20 August 2019

RE: MP11_0093 Pemulwuy Mixed Use Project, Redfern Modification 2 – Design Changes

Thank you for your correspondence dated 8 August 2019 inviting the City to comment on the proposed amendment (Modification 2) to 'Pemulwuy Mixed Use Project – Precinct 1' granted on 21 December 2012 by the Deputy Director-General under delegation of the Minister for Planning (ref MP11 0093).

| DWG No. | 1DA091 E          |

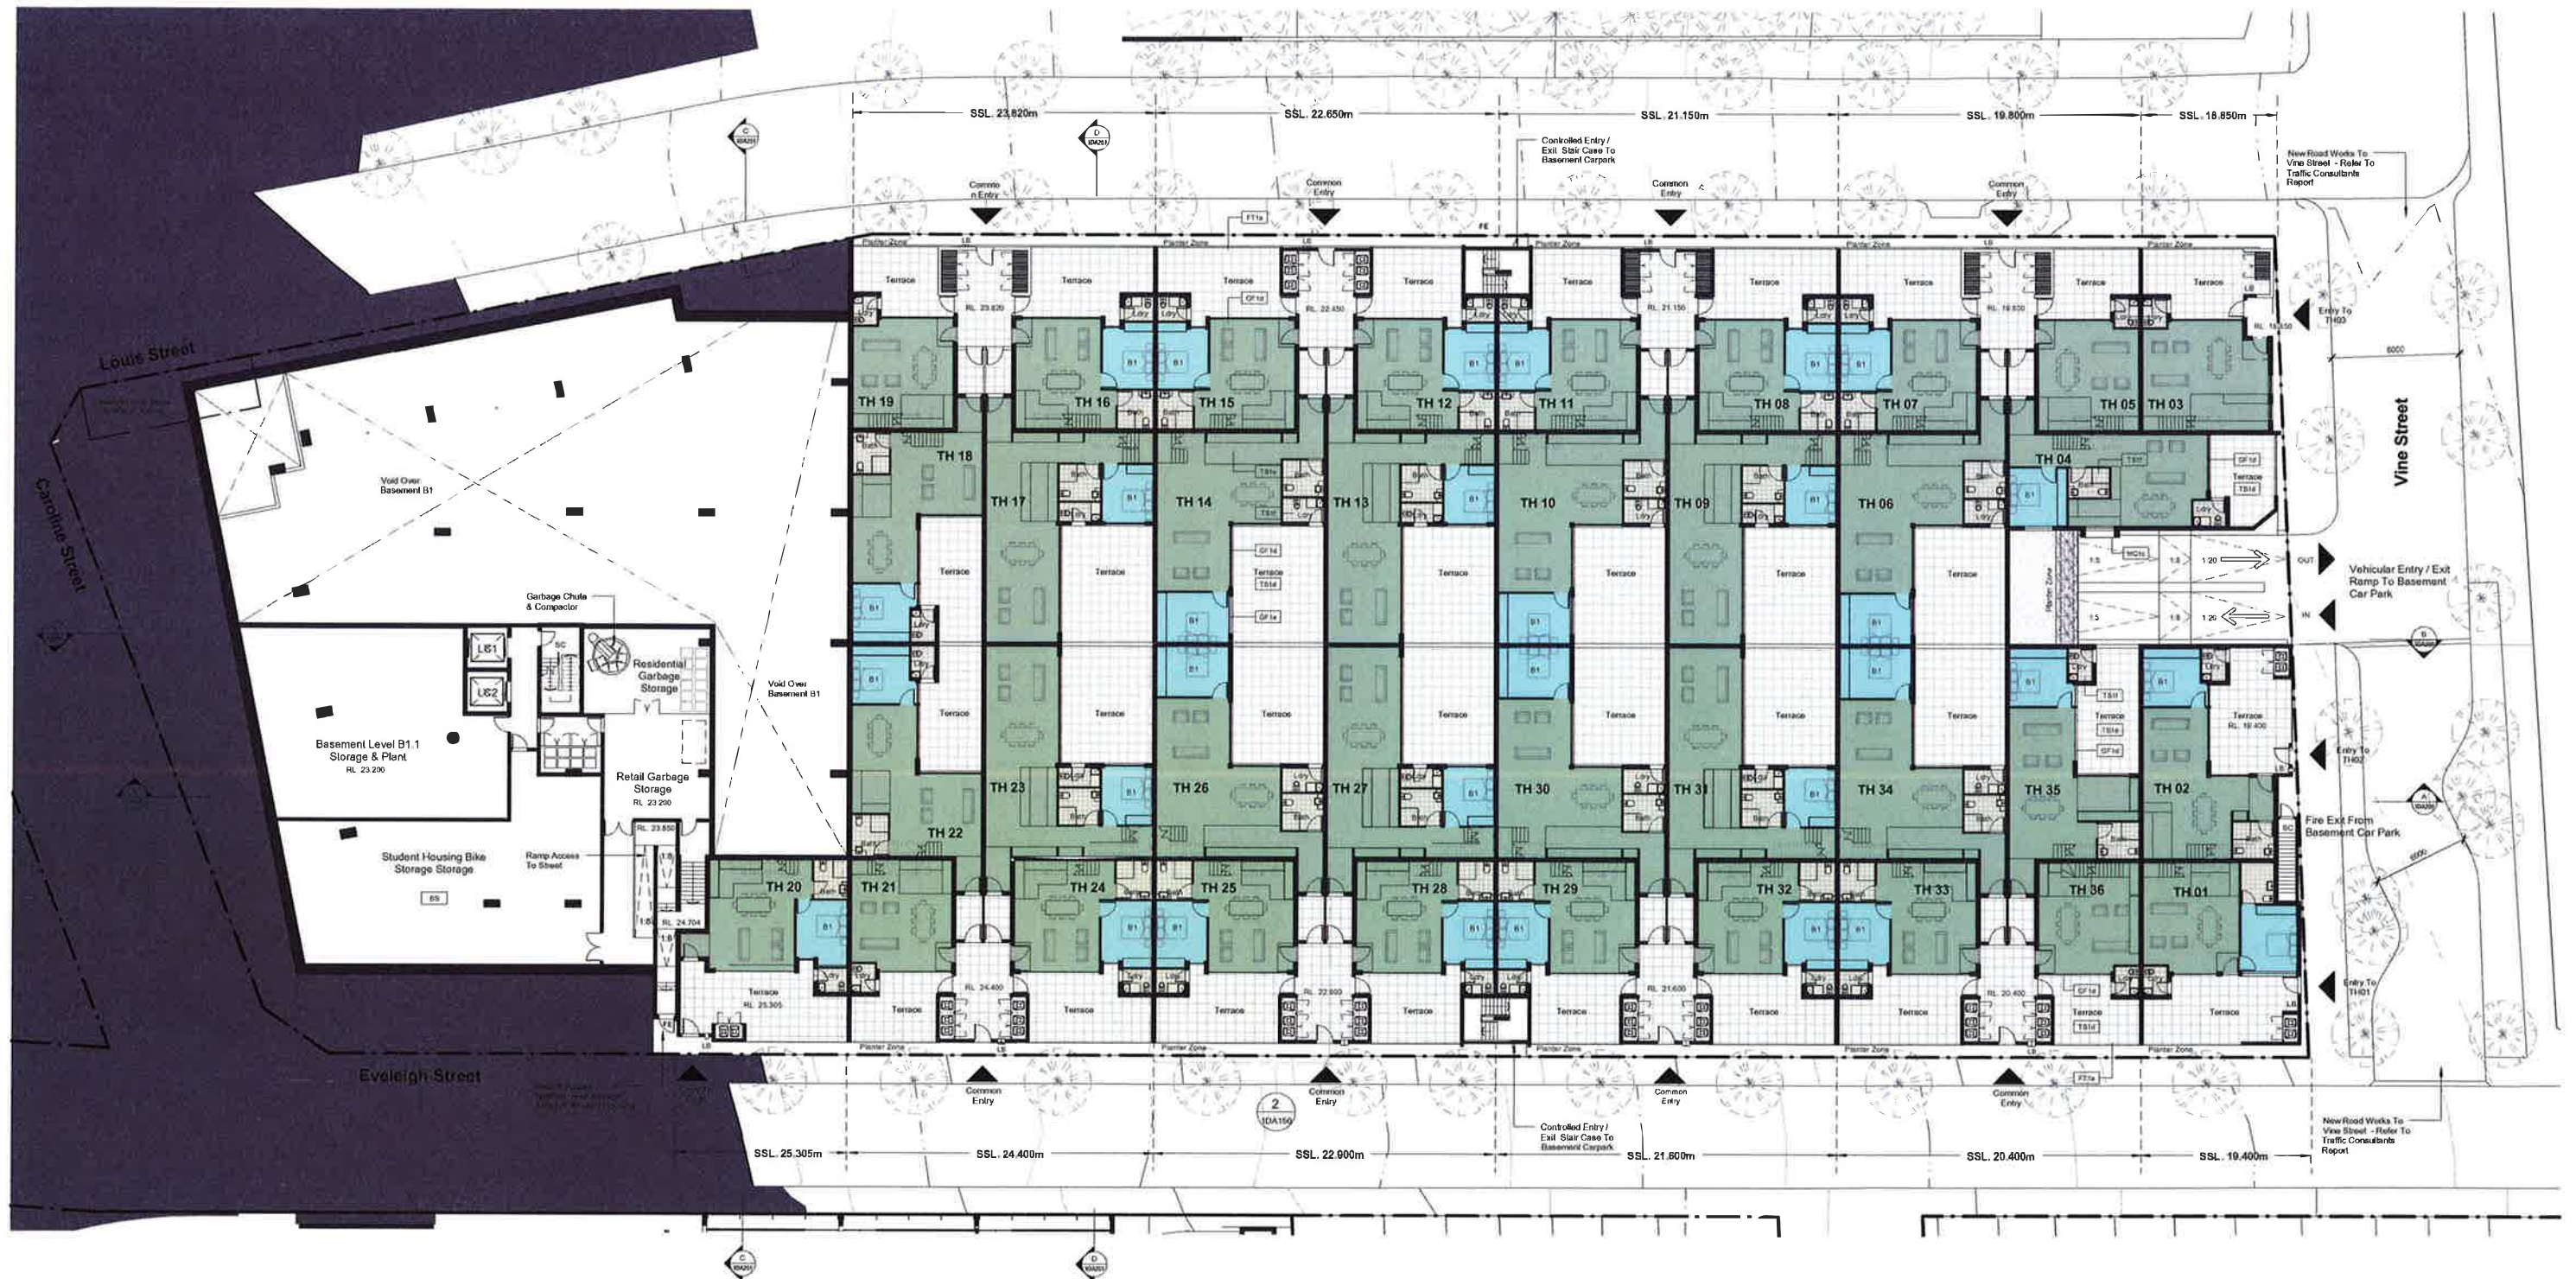
Further, the proposed pathway from the accessible car parking spaces to the adaptable units is convoluted and it is difficult to see how this complies with the relevant standards including Australian Standards relevant to accessibility. The plans show that to access Townhouses 16, 15, 12, 11 and 08, a person must exit the building and traverse around to the other side of it via the roadways. The '*Statement of Compliance – access for people with a Disability*' prepared by Accessible Building Solutions and dated 03.06.2019, Page 4, should be queried where it states 'access has been provided from the main pedestrian entry to the entry doors of all SOUs on all levels by means of a lift'. This doesn't seem to be the case.
